Engineers Comments Regarding Surface Water Drainage

Application Reference:	LY/13/25/PL	Reviewer Reference:	ADC/EXT2/89
Planning Officer:	Amber Willard	Date of Review:	03/03/26
Site Name:	Back Arun Fishery North of Arundel Station Arundel BN18 9JJ		
Application Description:	Siting of 3 No. temporary structures and associated works. This application is in CIL Zone 3 (Zero Rated) as other development.		
Assessment Number:	1 of 1

Figure 2.2 - Existing Site Plan

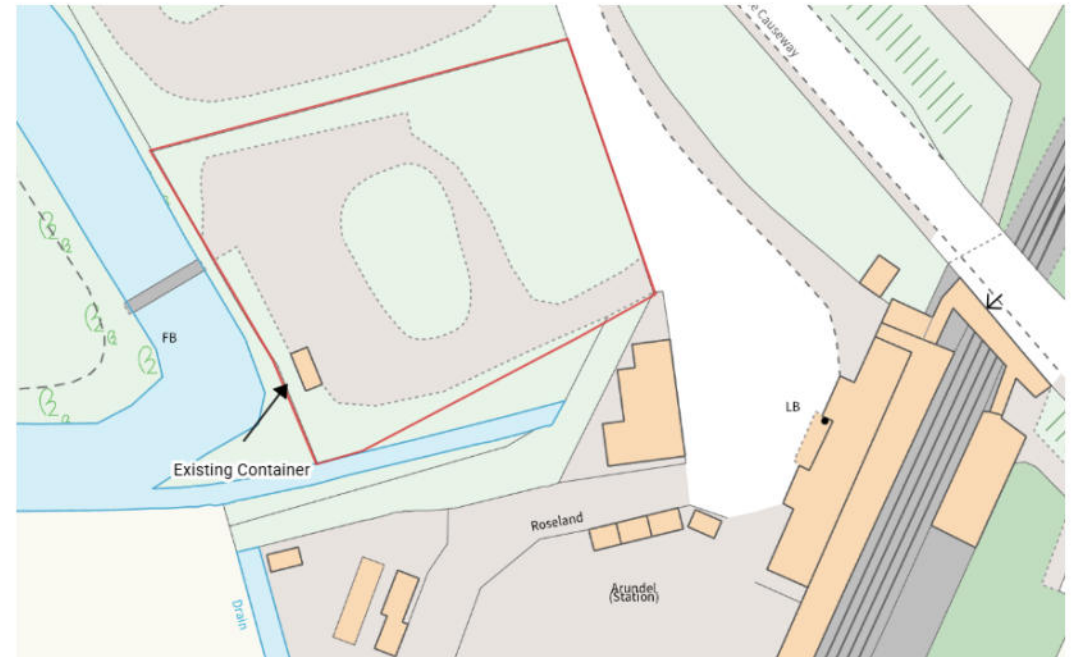
- 0.1. The FRA states in the section titled Surface Water Flood Risk Mitigation "The applicant has confirmed that the area where the proposed units will be installed is already underlain by hardstanding" Based on the drawings included in the FRA and satellite imagery, this does not appear to be the case, however an aerial photograph dated 2001 has been provided showing hard standing.
- 0.2. It also states "As such it is considered that the development in its current form will not lead to a significant increase in surface water run off rates and volumes when compared to the pre-developed

Figure 4.1 - Proposed Site Layout

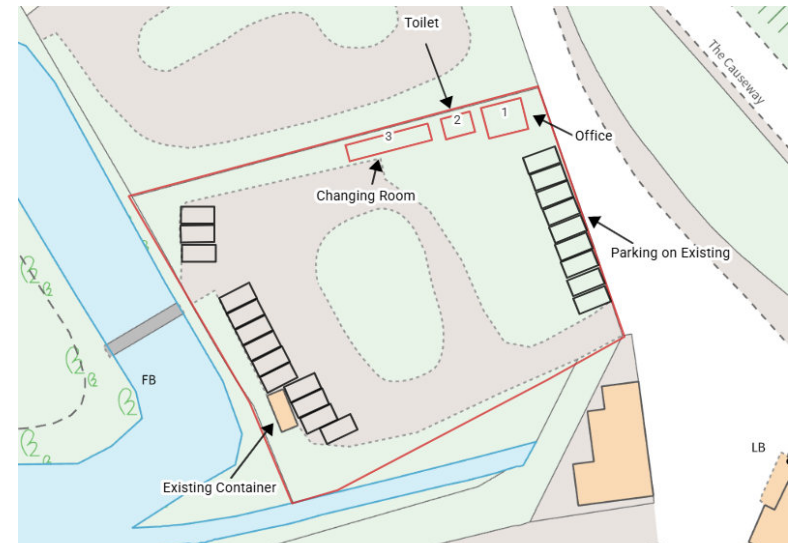
situation, and a surface water drainage strategy is not required". It then goes on to give advice regarding drainage proposals. Given that the proposed units appear to be located on areas that are not currently underlain by hardstanding, and advice is given regarding drainage features, a drainage strategy is required showing that the proposals meet the requirement of the National Standards.

8.4. In order to overcome the objection, the applicant should submit information demonstrating how the critical items above have been addressed or the justification for departures from the 7 standards. Information should also be provided demonstrating that the removal of the overgrowth from the existing hardstandings will not be detrimental from a surface water drainage/flood risk point of view.
